FAO: Planning Department,  
Welwyn Hatfield Borough Council

Ref: 6/2022/2801/MAJ  
Date: 09/02/2023

## HISTORIC BUILDINGS AND CONSERVATION ADVICE

**RE: *Campus East Car Park, College Way, Welwyn Garden City, AL8 6DG***

Figure 5.6: Elevation and feature corner of Block A. Source: Architect's DAS.

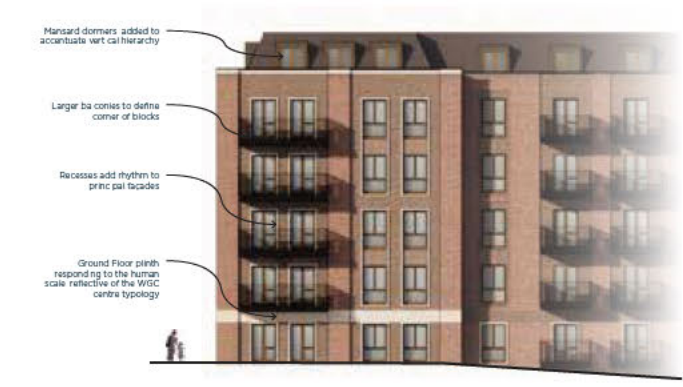
- The western elevations of proposed Blocks A and B face into the Conservation Area and are key gateway buildings into the development. Page 41 of the Design and Access Statement provides images of feature corner buildings within the Garden City town centre, including those flanking Howardsgate. However, the proposed corner/key buildings do not successfully reference the examples given. They lack symmetry due to projecting balconies and differing fenestration design, the roof height remains the same as the adjacent block and the stone plinth band is a minor point of difference.

Figure 5.4: Typical bay elevation Blocks A and B. Source: Architect's DAS.

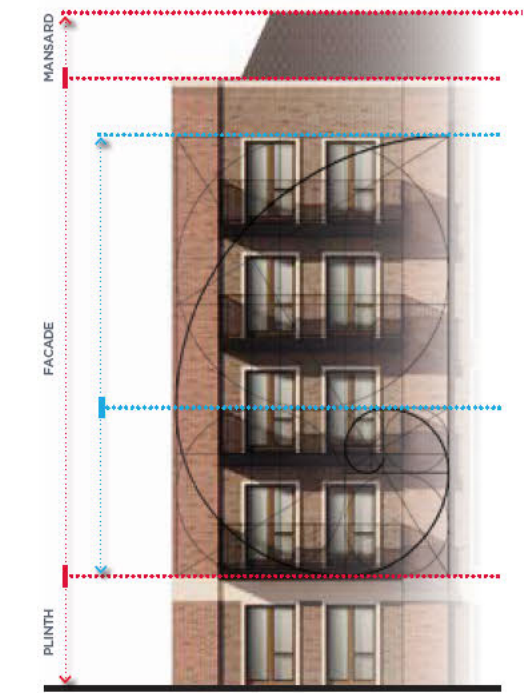
- Also considering the view along College Way, Blocks A and B have proposed projecting balconies which encroach on the view through to Block H and create a more cramped appearance to the development., as well as raising the same concerns about domestic paraphernalia. The position, design and number of projecting balconies should be reconsidered, particularly as they are bolt-on features.

- The proposed mansard dormers, whilst not adding to the overall height of the buildings, increase the visual prominence of the mansard roof which should not be a prominent feature, especially on the taller blocks. The heights of Blocks A and B need to be appropriate to the Conservation Area and the creation of another floor with the addition of the dormers is not considered to be sympathetic as the Blocks appear out of scale with the Conservation Area.

Figure 7.1: Map identifying 4 viewpoints selected for assessment. Approximate site boundary highlighted in red.

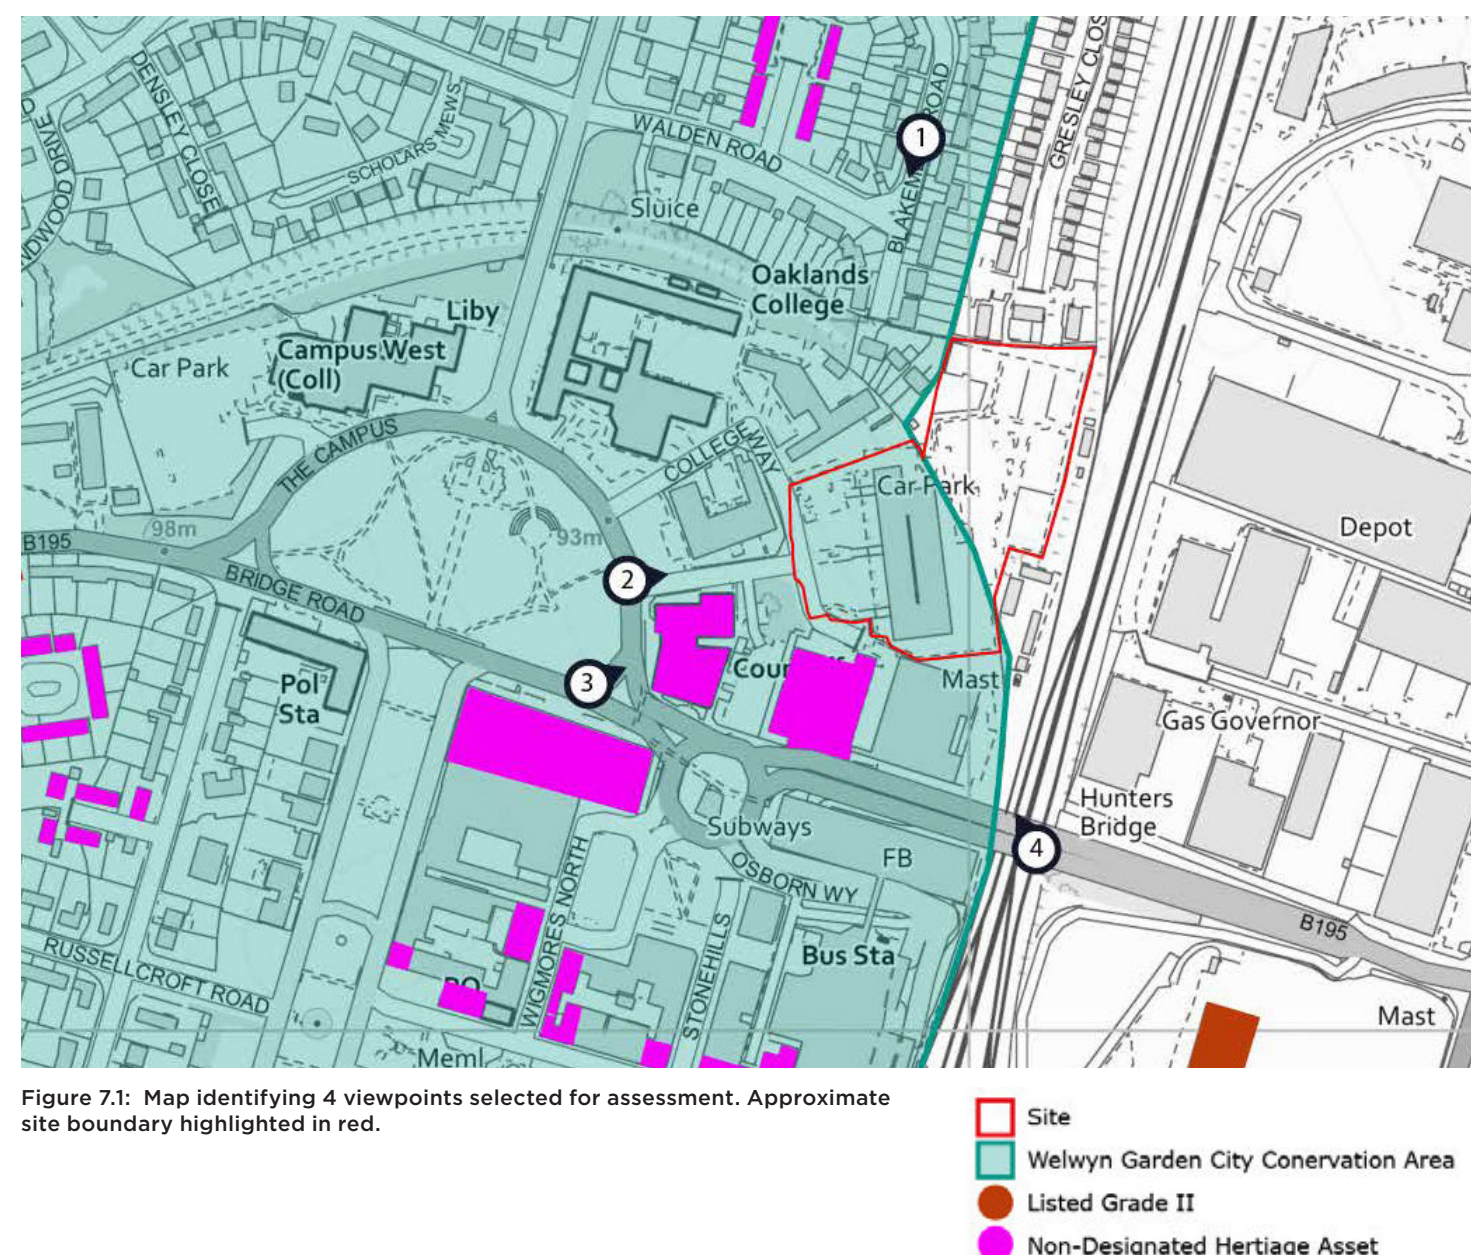
The viewpoints within the Heritage Townscape and Visual Impact Assessment (HTVIA) were agreed as per the plan at figure 7.1. Viewpoint 2 has been taken at an angle looking down College Way from

the crossing point on The Campus and so it does not fully take in the long view from The Campus down College Way to the development site. It is understood that in townscape terms the viewpoints are taken from positions where people will more commonly view the development, however, heritage considerations can differ from townscape considerations. In heritage terms the radial layout of The Campus and the views of the buildings around the edge of The Campus resulting from its radial layout is an important consideration. It is appreciated that there is no footpath on The Campus directly at the end of College Way looking towards the site, however, this view straight down College Way with the Council Offices to the right is considered to be significant in heritage terms and it would be beneficial to have a viewpoint from here to better understand the proposed scale of the buildings alongside the existing buildings on College Way. It was also suggested at pre-application stage that consideration was given to a CGI of this view rather than a wireline to fully understand the appearance of the proposed buildings from within the Conservation Area.

VIEW 1 - EXISTING: View south from Blakemore Road.

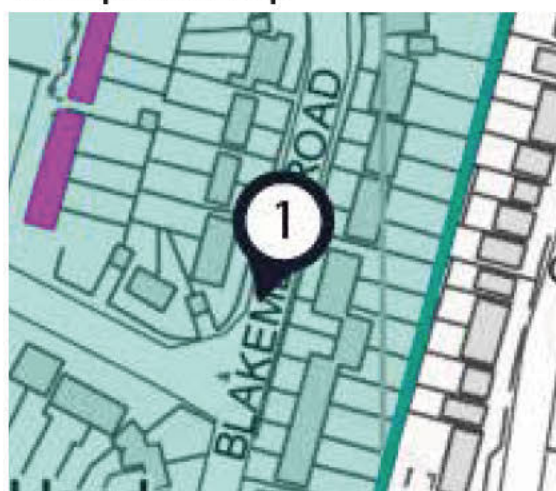
Viewpoint 1 within the HTVIA raises some concerns as the wireline shows how the proposed buildings will partially infill the sky gaps between the houses on Blakemere Road. The verdant character of streets within the residential areas of the Garden City contributes positively to the character and appearance of the Conservation Area. Sky gaps between buildings is part of this verdant, spacious character and the Viewpoint 1 wireline shows how the proposed development will impact this element of the streetscene here. In my opinion, this will result in some harm to the significance of the Conservation Area and the proposal will not enhance the visual amenity in this view.
